DRB Application No.: 09DRB-70163 Project # 1007505
 Project Name: Raymond Adkin
 Agent: Sian Culligan Phone No.: _____

Subdivision Name: RAYNOLDS ADDN BLOCK 39 LOTS 24A 24B 24C & 24D

DRB Comments

RE: Lots 22-24, Block 39, Reynolds Addition

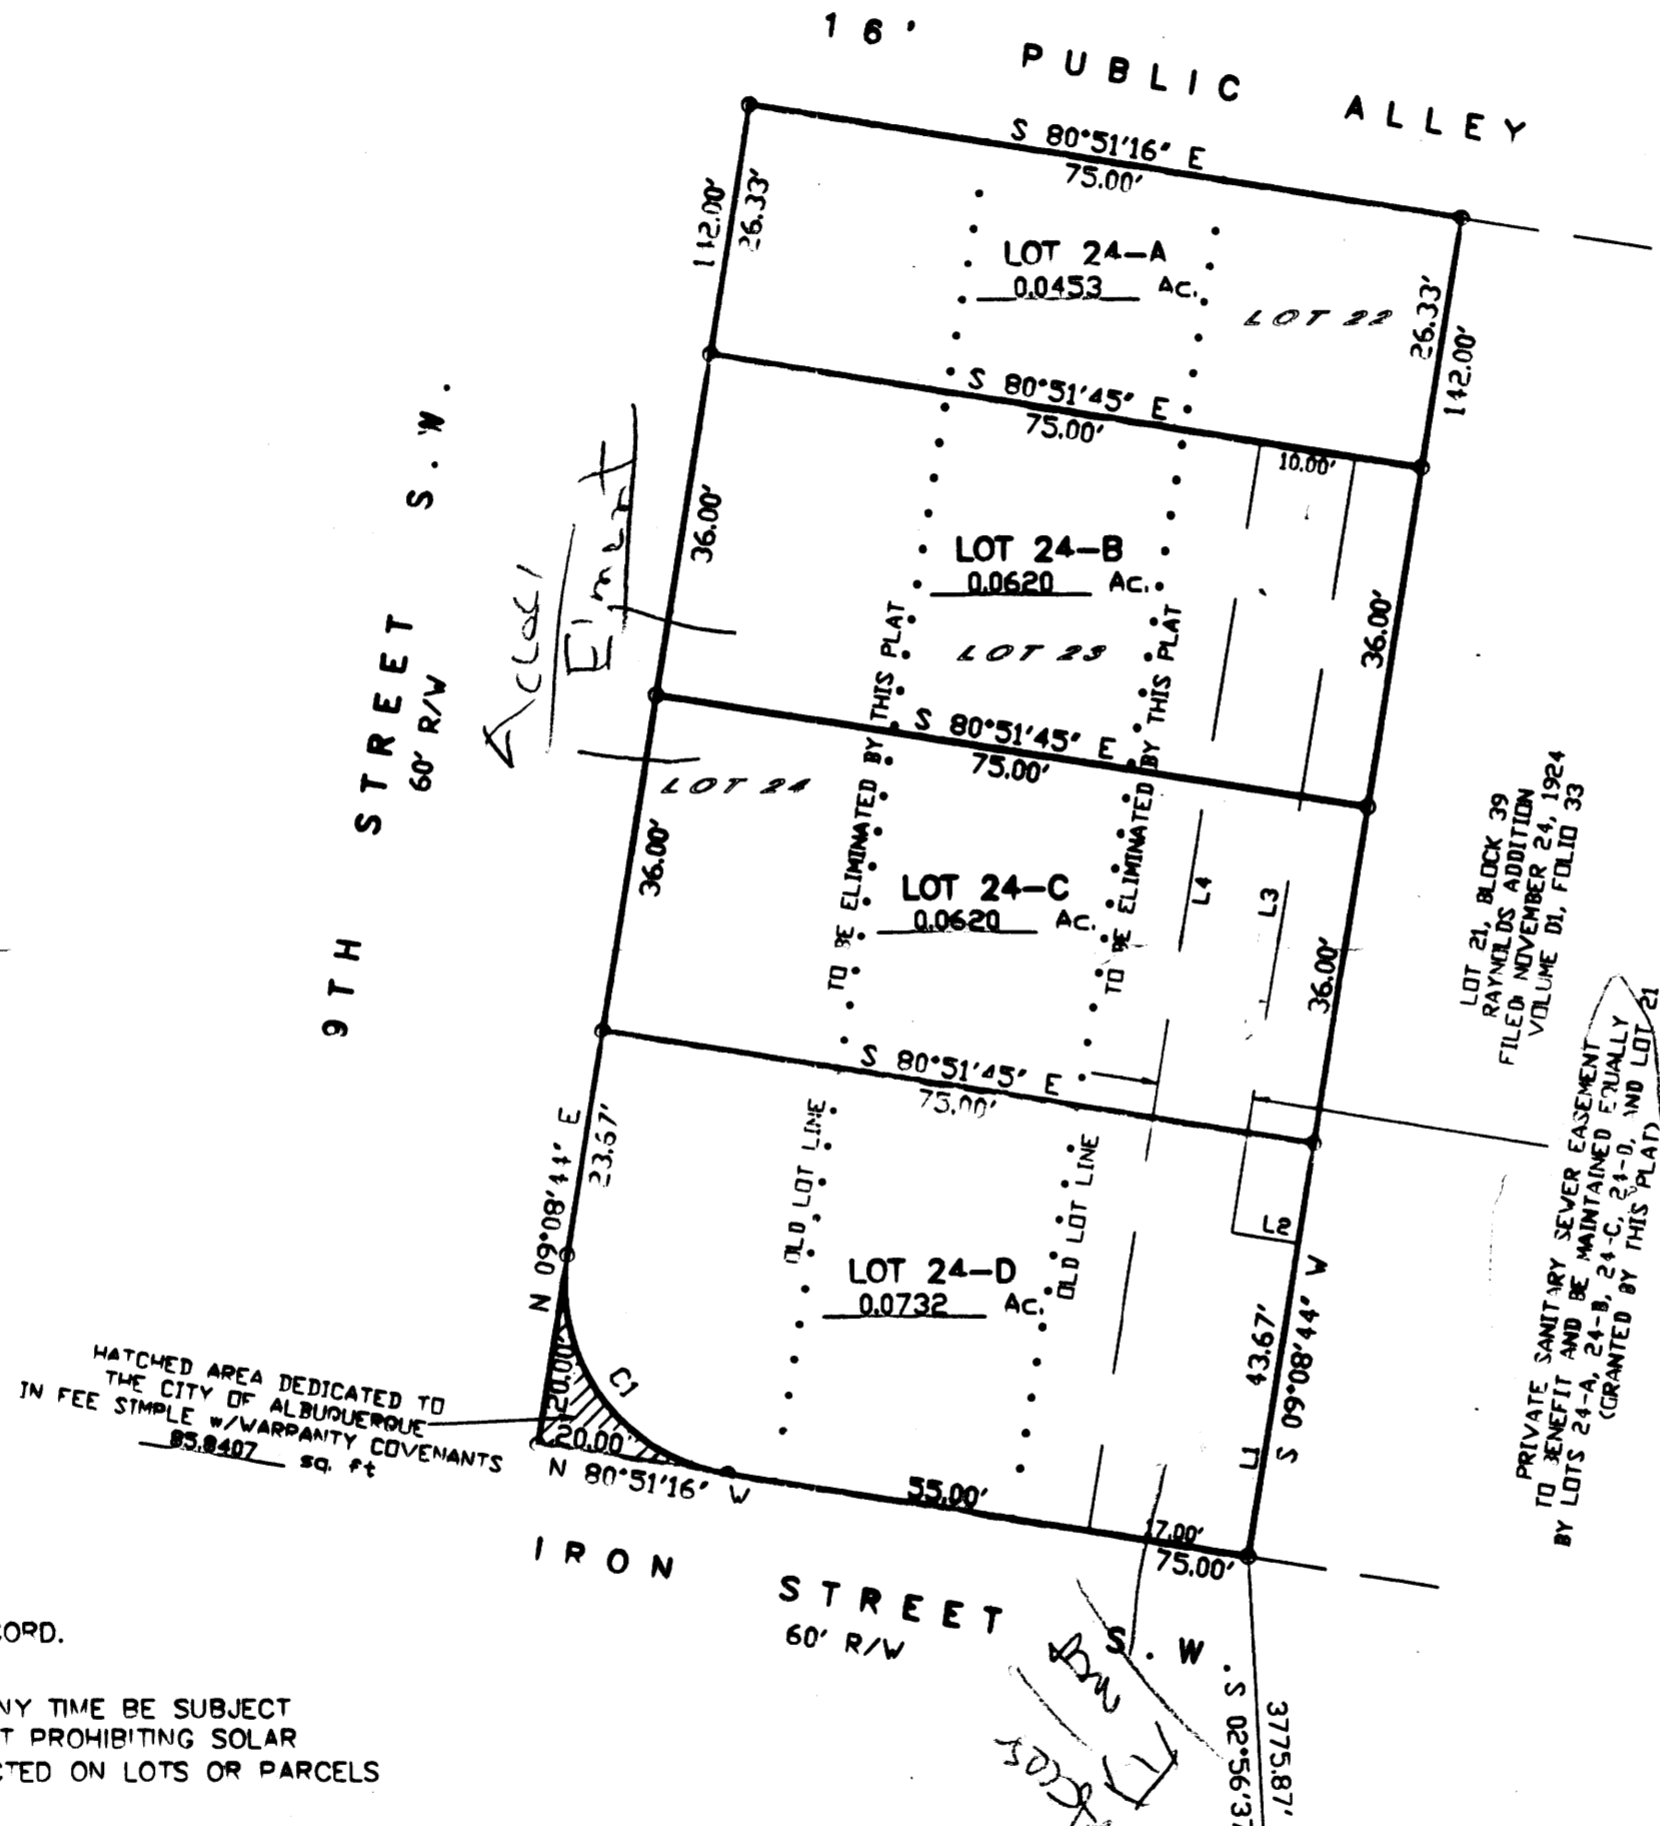
PLANNING (Last to sign): - move fence
- reciprocal E'ment 24-B/24-C

The fence for adjoining Lot 21 would have to be moved to the property line prior to Final Plat sign-off.
